Below are our comments on the proposals for extending 91 North Lane. We are the owners and residents of the adjacent property at 93 North Lane. We wish to register an objection to the scale and to the positioning of the proposed extension on the following grounds:

Project No: 2001-1	Drawing No: PL06	Revision: A
-----------------------	---------------------	----------------

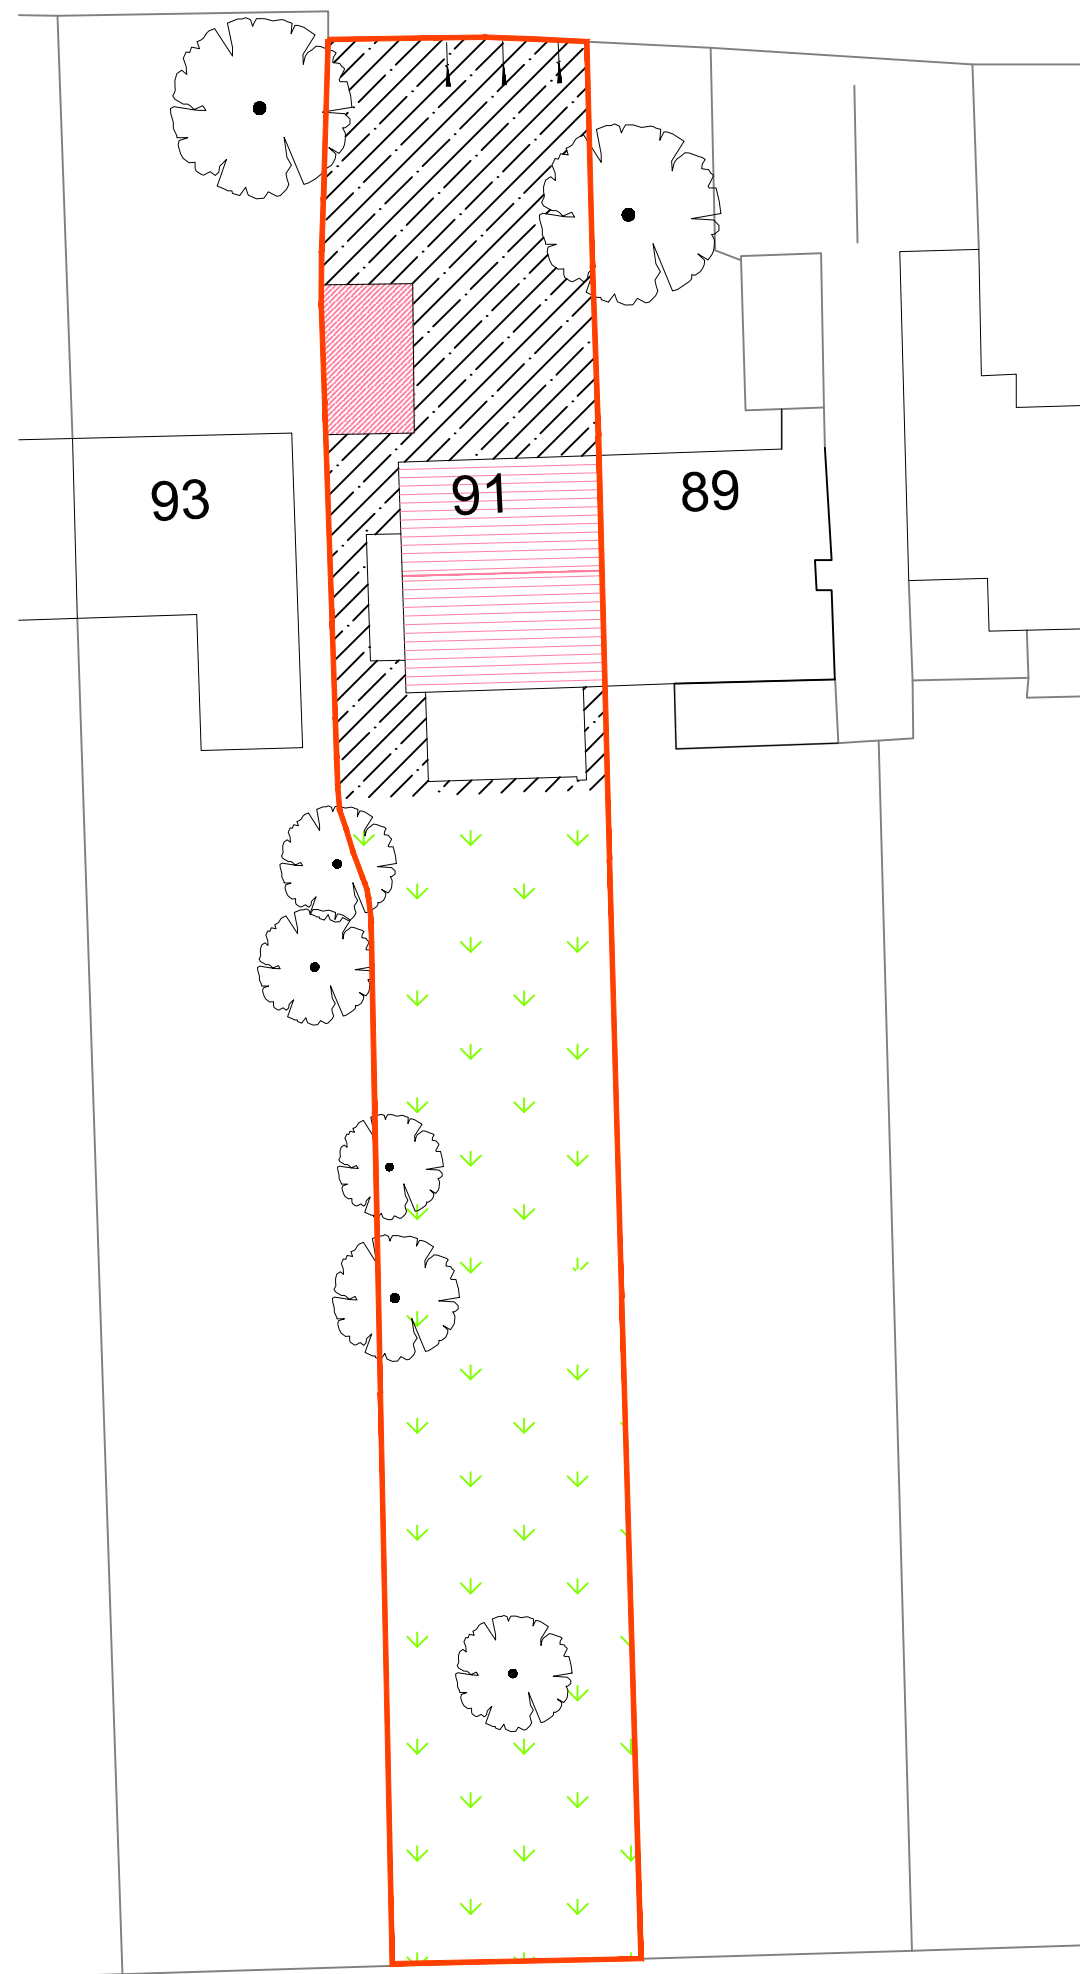
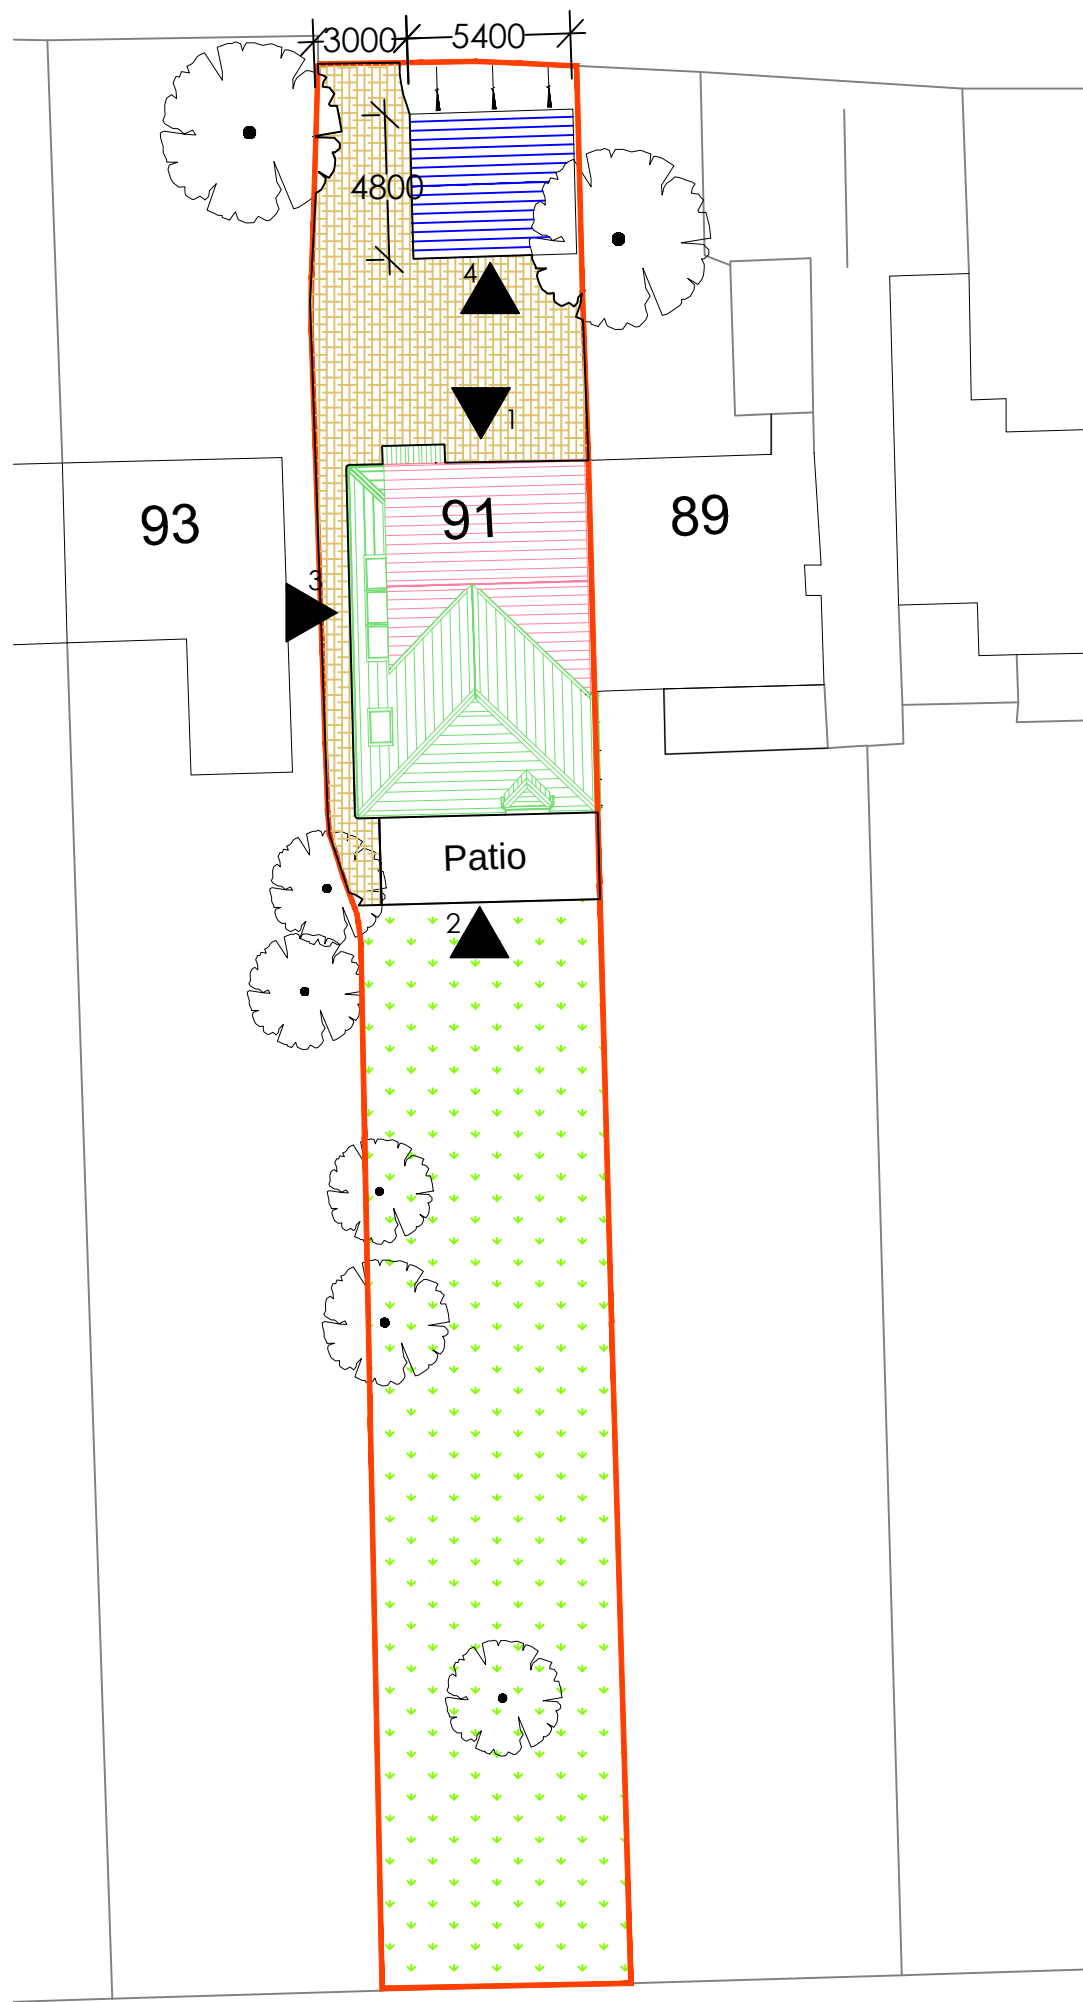
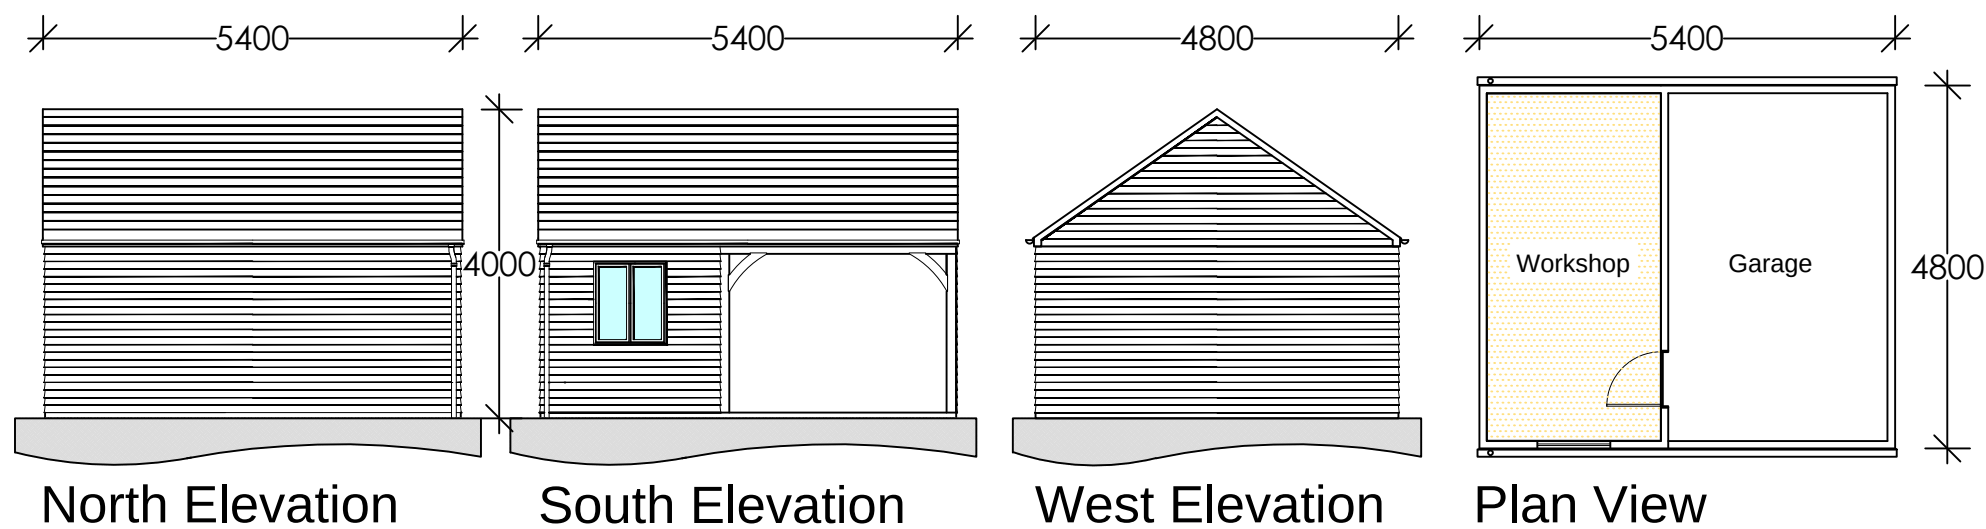
§	<i>Overshadowing</i> We note that the design of the extension has taken no account of the fact that there are three windows on the adjacent face of our property. The proposed extension would adversely affect the light in three primary rooms of our house: the hall on the ground floor and the two east-facing bedrooms on the first floor. For a substantial part of the morning the sun would be cut off behind the southern reach of the extension and the proximity and scale of the extension would affect light throughout the day. These rooms have no source of light other than our east windows; there are no windows on our north face, so that the lightness of a large portion of our house would be severely affected. We understand that <i>Right of Light</i> is protected under common law and by the <i>Prescription Act of 1832</i>: as all three windows on the east side of the house are more than twenty years old, they fall within the remit of these regulations. The light is already compromised on that side by the existing building; the proposed extension would present a serious obstruction, because of its proximity, length and height. As we believe that the extension would breach the 25 degree rule, as laid out in the <i>Building Research Establishment (BRE) document 'Site Layout Planning for Daylight and Sunlight: A guide to good practice'</i>, we would if necessary consider requesting a Local Authority survey to measure the impact of the proposals. We also believe that light into our south-facing windows would be affected by the height and length of the southerly extension, in contravention of the 45 degree rule (BRE document).

The extent of the development in a southerly direction would increase these factors and would create a tunnel-like sensation on the east side of our house. The proposed close proximity of the new structure is potentially threatening to the footing of our house. According to the <i>Party Wall Act 1996</i>, we are entitled to receive protection from any possible damage. As the bathroom of the proposed property would be on the west side, we also have serious concerns regarding the installation of drains in the narrow space available between the houses, bringing with it the potential for damage to our drains which are located on the same side. We are informed by the owners that the proposed extension along the west wall of number 91 will be a timber-framed construction; because of the close proximity, less than a metre from our party wall, there would be a potential fire risk.
§	<i>Character of the neighbourhood</i> We observe from the plans that the proposed extension would increase the volume of number 91 by more than a third. We believe that this may contravene local planning policy. The properties 89, 91, 93 and 95 North Lane form a group of modestly proportioned cottages which contribute significantly to the character of this area of the village. The proposed extension to number 91 would alter the harmoniousness of this grouping.

Project No: 2001-1	Drawing No: PL03	Revision: A
-----------------------	---------------------	----------------

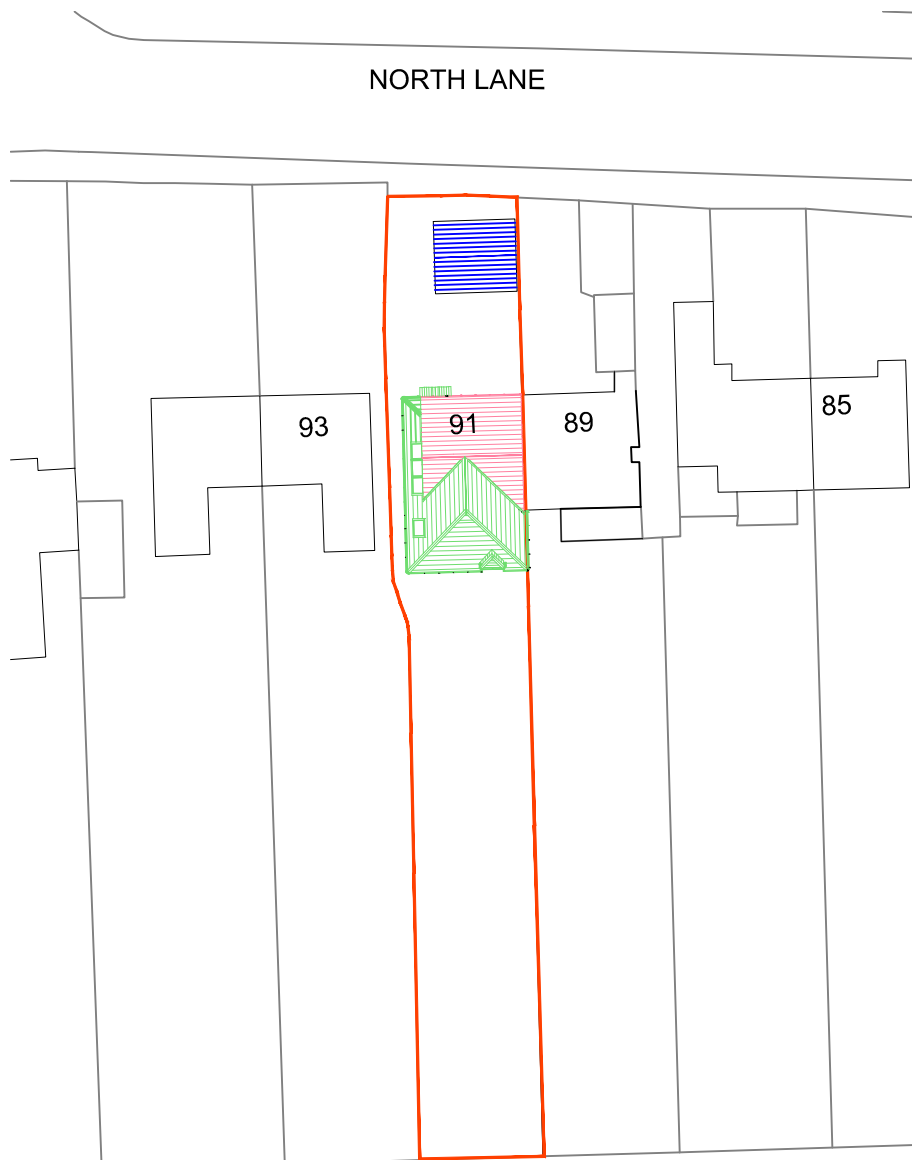
§	<i>Overbearingness</i> Because of the scale of the proposed two-storey development along the west wall of number 91 and because of its very close proximity to our property, our path and entrance would feel constricted. The sensation looking out from our hall and from our two east-facing bedrooms would be one of claustrophobia. The proposed two-storey development would extend further south than the wing of our house; it would be evident to us in our ground floor kitchen and our first floor bathroom. It would overlook and alter the character of our garden.
§	<i>Proximity</i> The proposed extension would come within less than one metre of our party fence wall, in what is already a narrow corridor between the two properties. For the reasons outlined above, this close proximity would affect both the light and the atmosphere of our property.
